27 November 2024

Re: Billabong Creek Environmental Water Regulators (SSI-50831979) – Environmental Impact Statement

NSW Department of Primary Industries and Regional Development (DPIRD) – Fisheries has reviewed the Billabong Creek Environmental Water Regulators (SSI-50831979) EIS exhibited to the public between 1 November 2024 and 28 November 2024 and provides the following submission in relation to the aquatic ecological implications of the project.

FISHWAY CONCRETE PLAN
SCALE 1:50

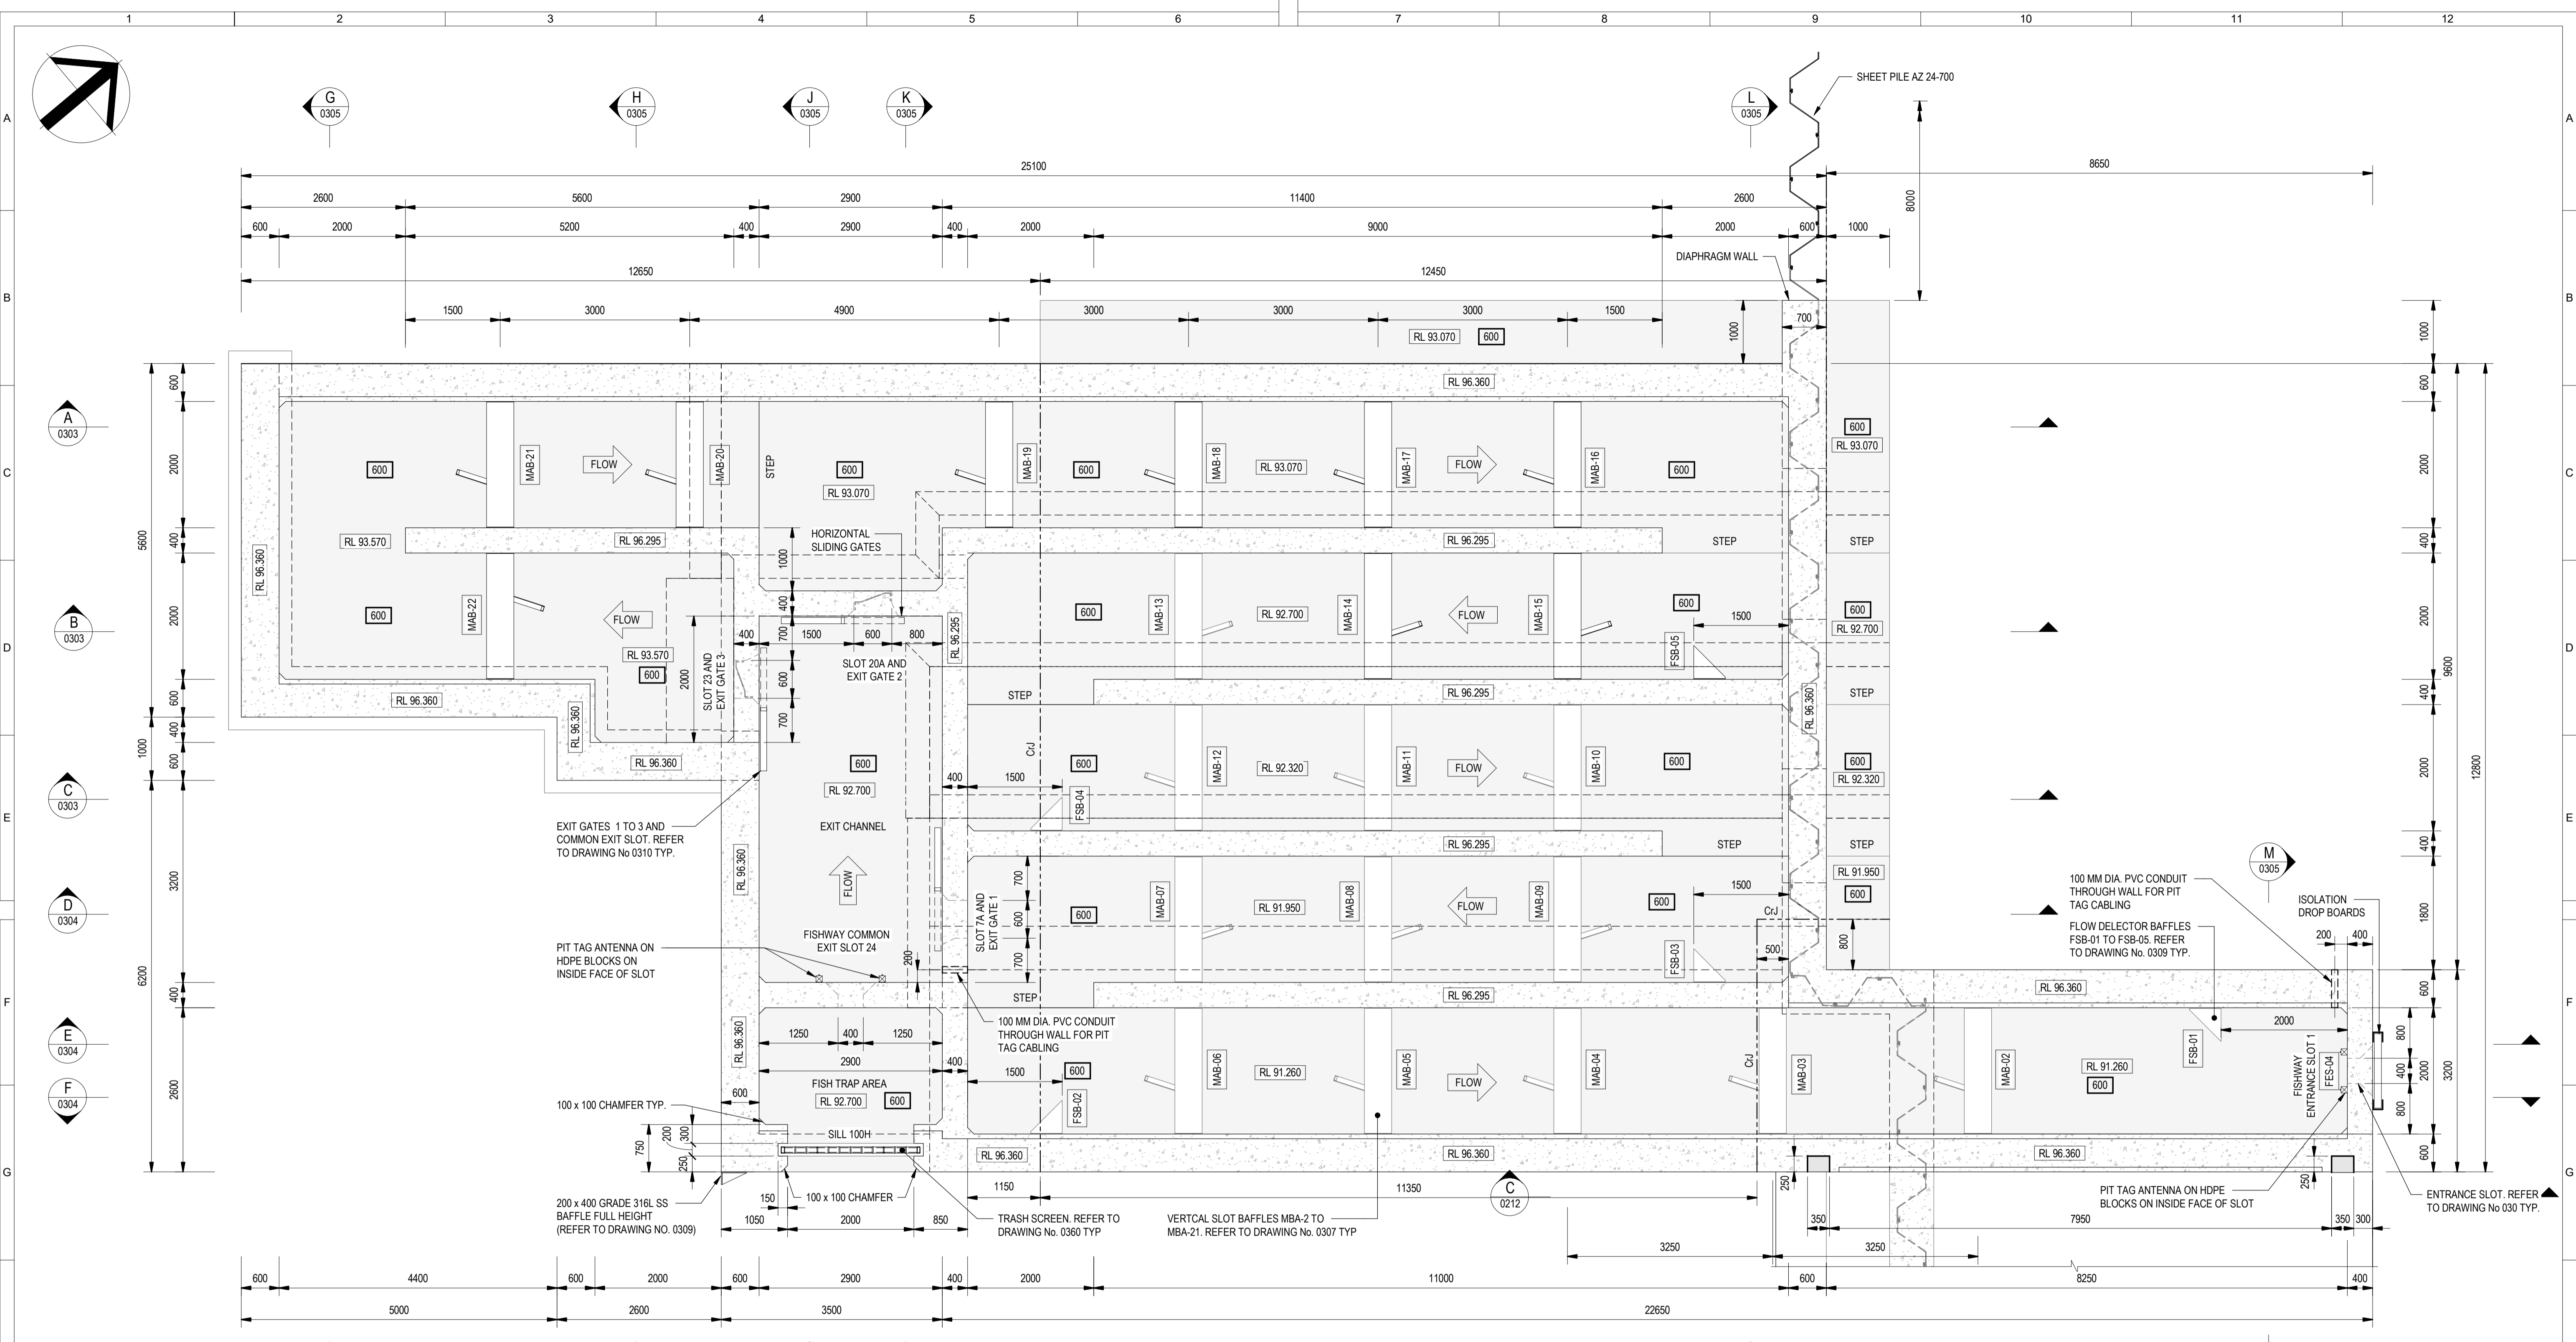
Issue	Summary Issue	Detail of the Issue	Further Work Required
O1	Final weir and fishway design	<p>DPIRD Fisheries understands that DCCEEW is yet to finalise the weir and fishway design. The EIS indicates that further refinement would be developed during the detailed design phase and consider submissions received on the EIS.</p> <p>s218(5) of the FM Act states that <i>A public authority that proposes to construct, alter or modify a dam, weir or reservoir on a waterway (or to approve of any such construction, alteration or modification)–</i></p> <p style="padding-left: 40px;"><i>(a) must notify the Minister of the proposal, and</i></p> <p style="padding-left: 40px;"><i>(b) must, if the Minister so requests, include as part of the works for the dam, weir or reservoir, or for its alteration or modification, a suitable fishway or fish by-pass.</i></p> <p>Final designs will require s218 fishway suitability approval by the Minister for Primary Industries or his/her delegate.</p>	<ol style="list-style-type: none"> 1. DPIRD Fisheries are members of the Design Focus Group that are working through detailed design for Hartwood and Wanganella. If there are major designs alterations to the weir/weir gate/fishway configuration, related recalibration of any fishway assessment inputs (e.g. hydraulic modelling) will be required. 2. DCCEEW required to request acceptance from DPIRD Fisheries for final fishway designs to meet s218 FMA Act fishway suitability.
